CITY OF ALBUQUERQUE

RE: 413 Harvard Drive SE (File: K16D083)
Grading and Drainage Plan
Engineer's Stamp Date – 10/19/15

A PROPOSED
GRADING AND DRAINAGE PLAN
FOR RESIDENTIAL UNITS AT
413 HARVARD DRIVE S.E.
ALBUQUERQUE, NEW MEXICO
OCTOBER, 2015

A PROPOSED  
GRADING AND DRAINAGE PLAN  
FOR RESIDENTIAL UNITS AT  
413 HARVARD DRIVE S.E.  
ALBUQUERQUE, NEW MEXICO  
OCTOBER, 2015

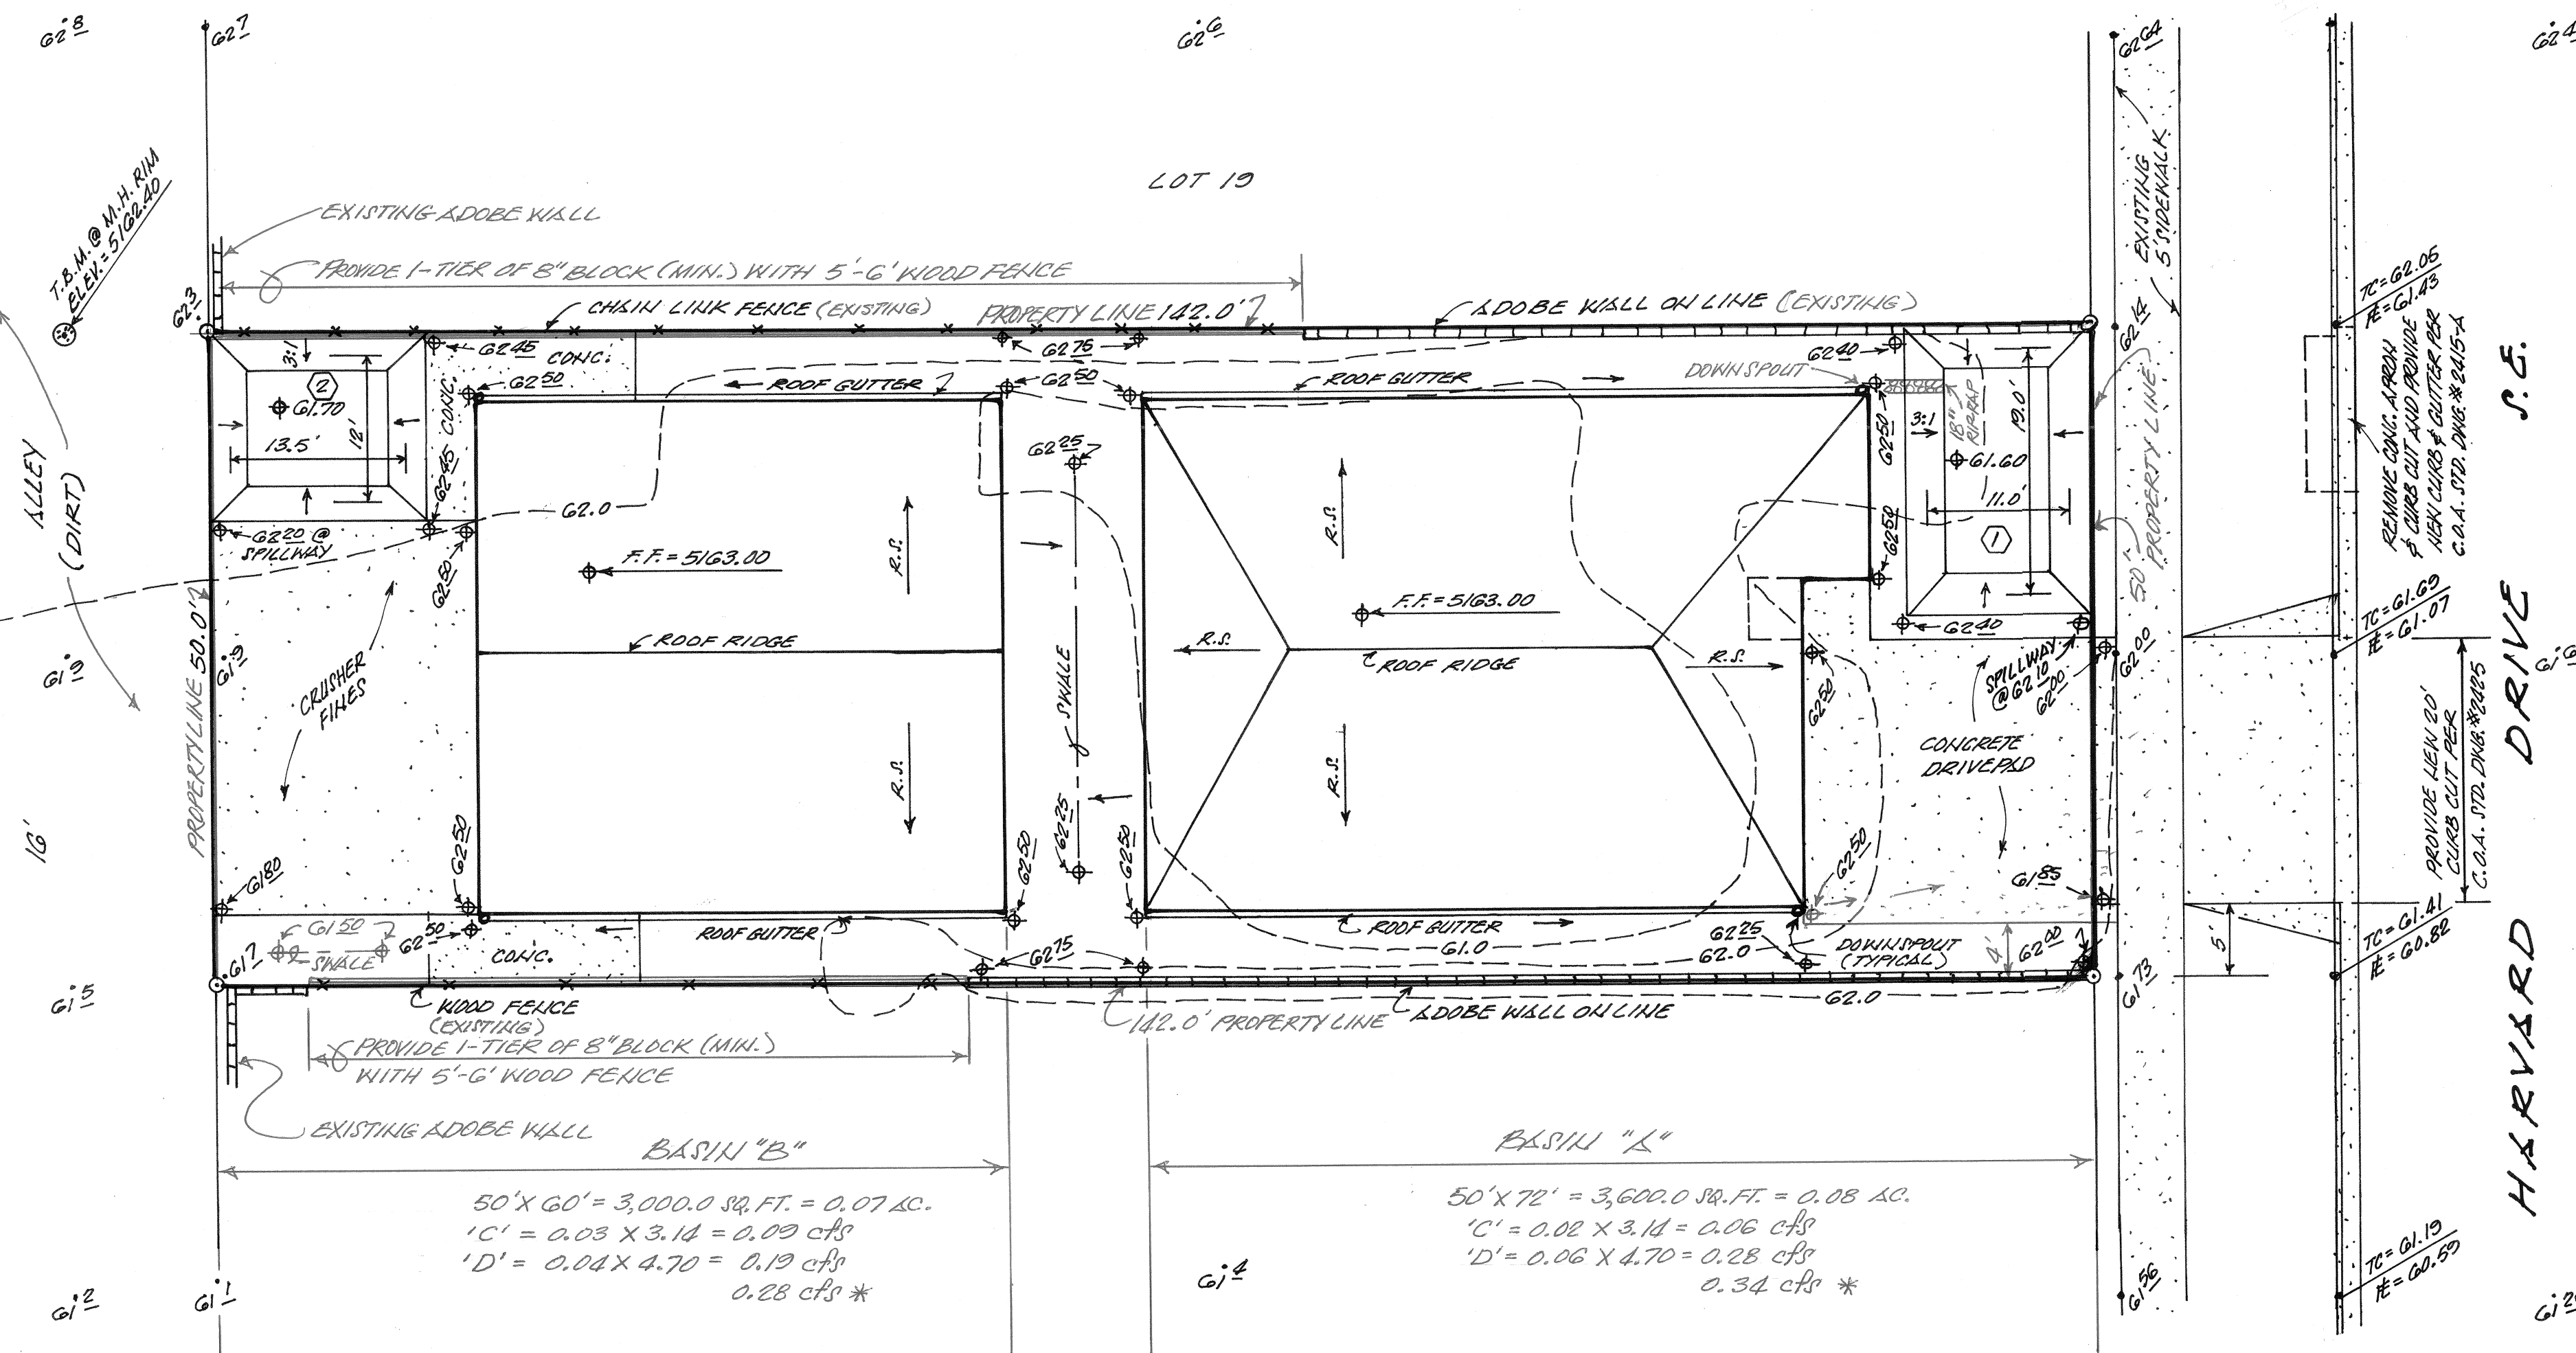
- Provide offsite discharge flows to the alley west of the property and to Harvard Dr. east of the property. Drainage patterns for both the alley and Harvard Dr. appear to flow south. Ensure that offsite flows can be captured by downstream inlets and that no properties are adversely affected by discharged flows.
- Provide documentation allowing flows to enter alley west of the property.
- Provide adequate detailed information on the Grading Plan to ensuring no flows enter adjacent properties to the north and south.
- Show limits of concrete removal at the northeast property corner to accommodate First Flush Pond 1.
- Clearly identify and define property lines.
